# City of Albuquerque Stormwater Construction Site Inspection Report

Project Name:	Legacy NAA Apartments II		
Location:	Alameda and San Pedro		
Site Contact Name & Agency	Jeff Garcia - Legacy <a href="mailto:jgarcia@legacydm.net">jgarcia@legacydm.net</a>	ESC File No.	C18E083
		NPDES Id. No.	NMR1000QH
Inspection Date:	05/13/19	Start/End Time:	1130/1200hrs
CoA Stormwater Inspector:	Timothy E. Sims		
Construction Phase:	building slabs		
Type of Inspection:	<input checked="" type="checkbox"/> Regular	<input type="checkbox"/> Storm Event	<input type="checkbox"/> Post Storm Event >0.25" <input checked="" type="checkbox"/> Complaint <input type="checkbox"/> Follow Up

EROSION AND SEDIMENT CONTROL PLAN

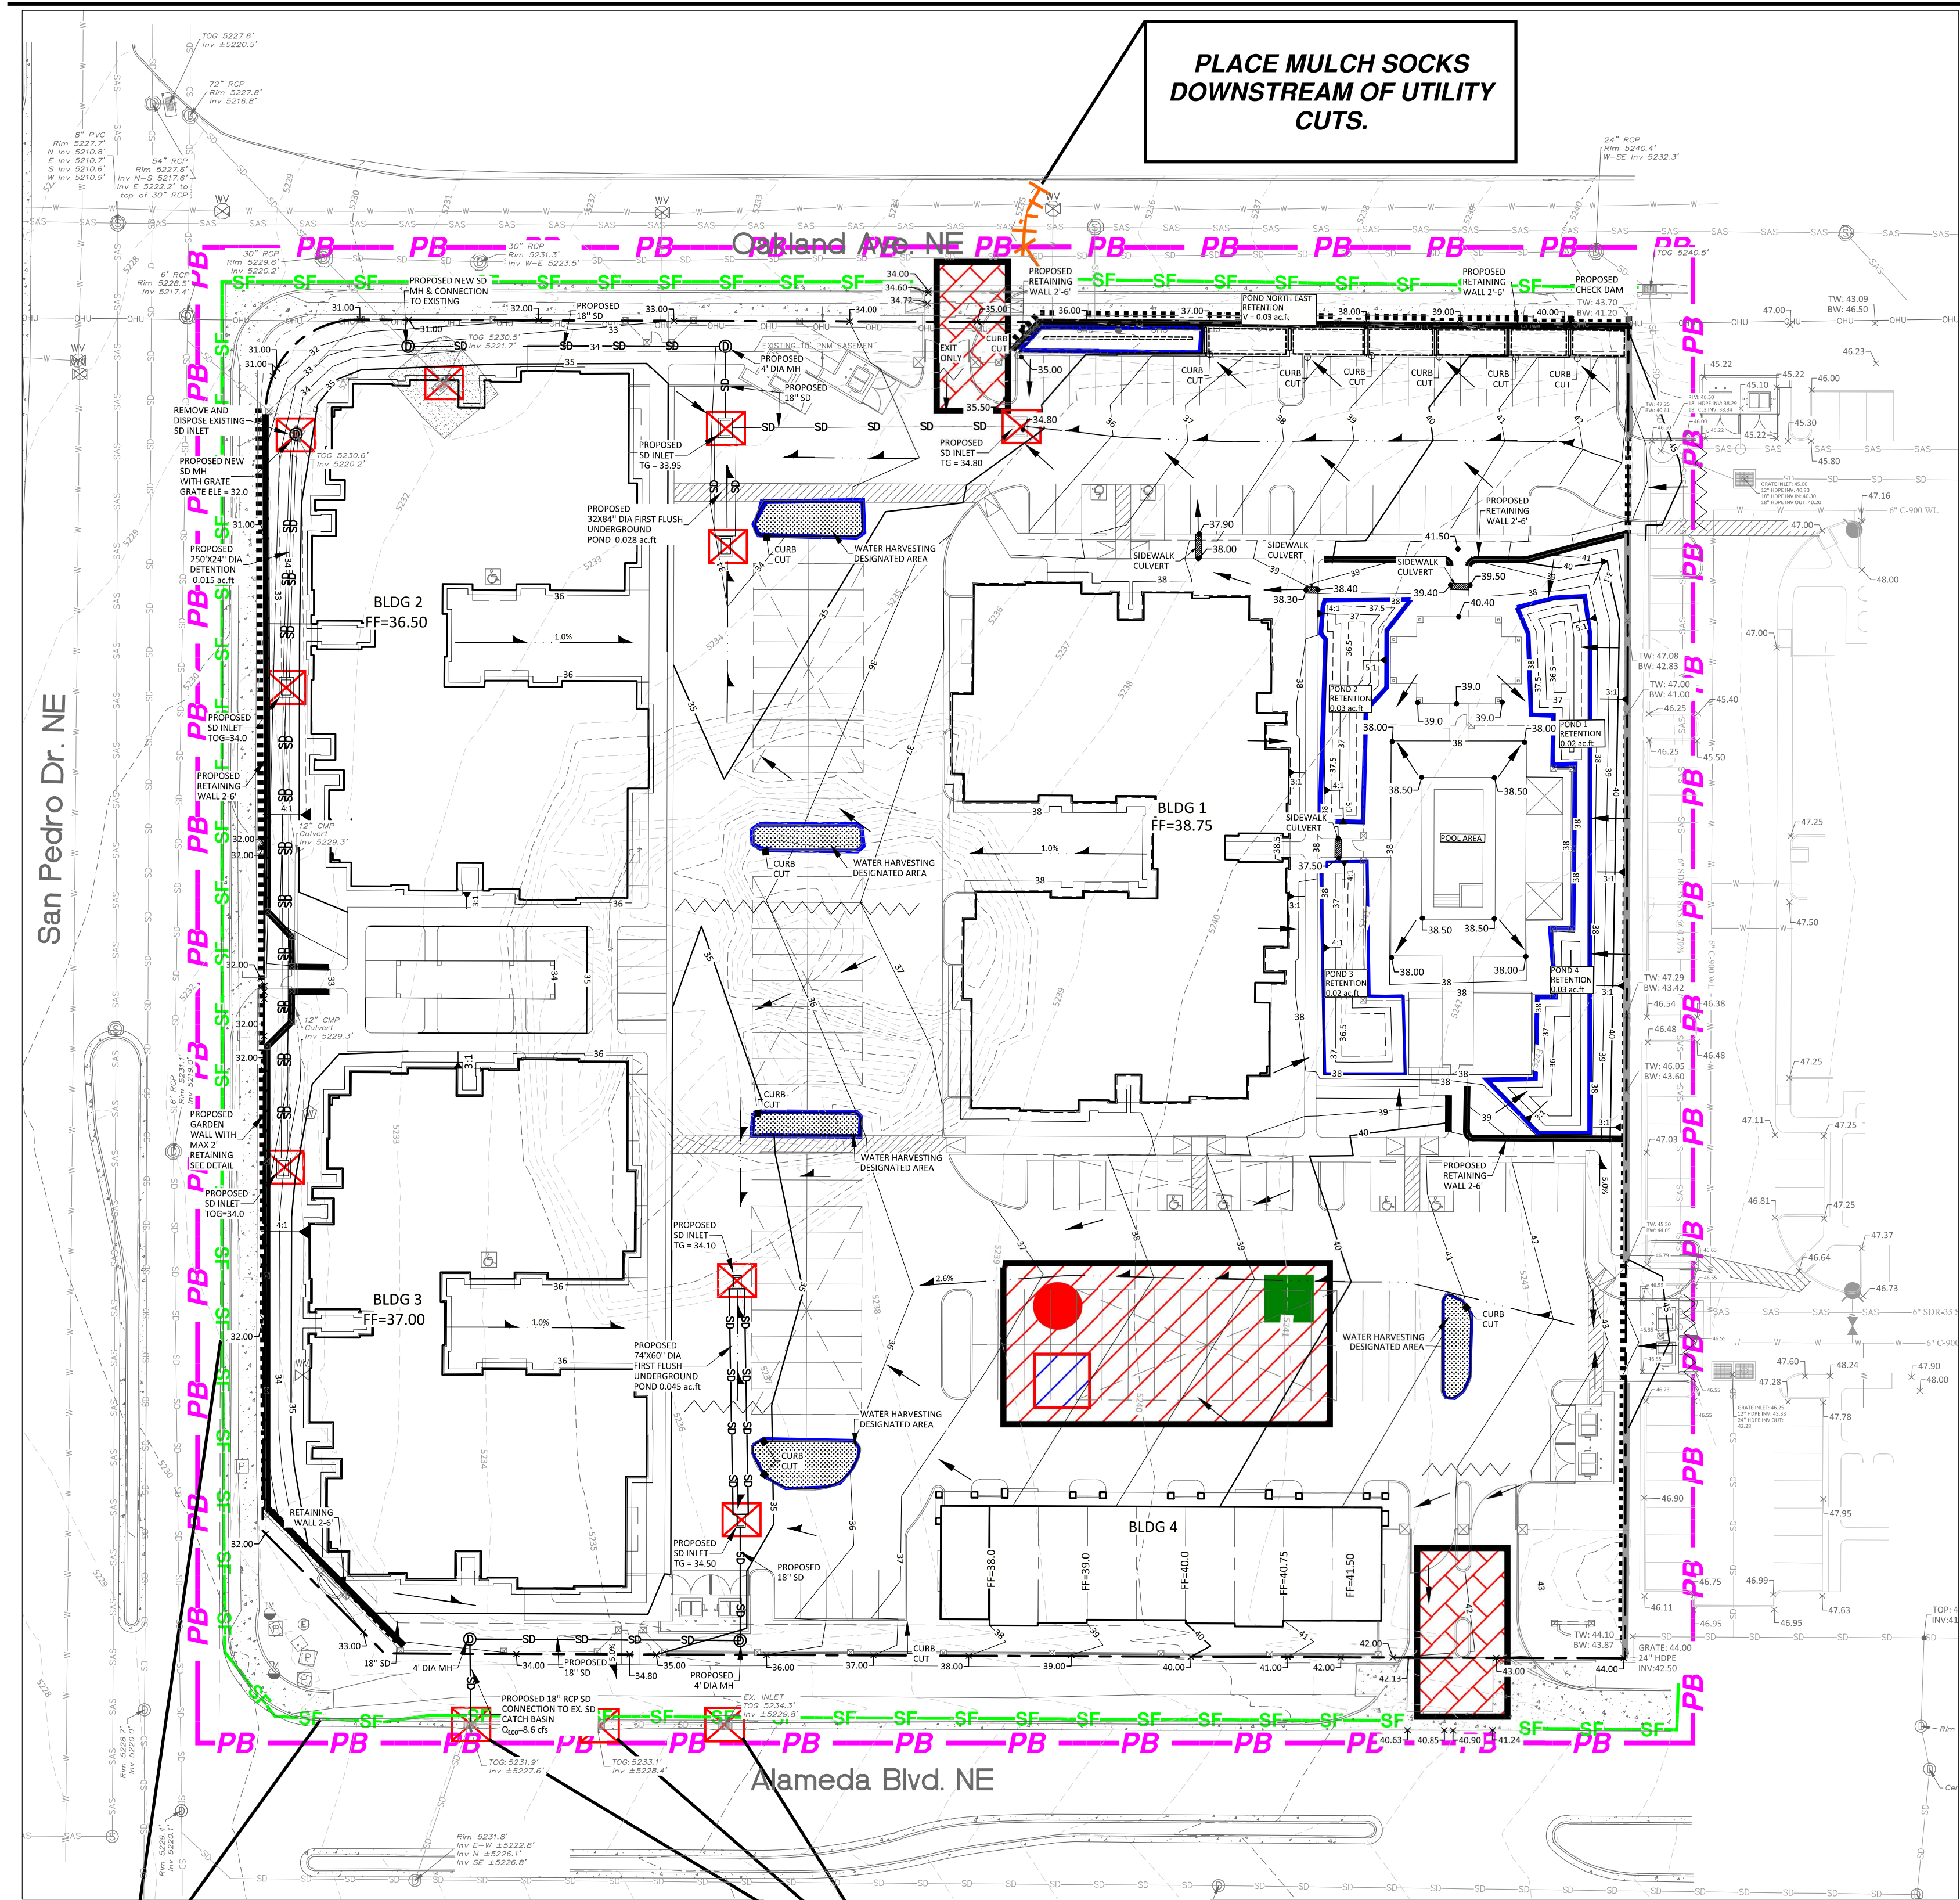
Item Number	Deficiency/ Corrective Action		
1	Oakland Avenue has too much dirt in the street. Sweeping and removal occurring during inspection with the utility cuts to be paved by Wednesday this week.		
2.1	Discharge off site? (Y/N)	No	
4	Self Inspection Reports	requested	Latest report Date:
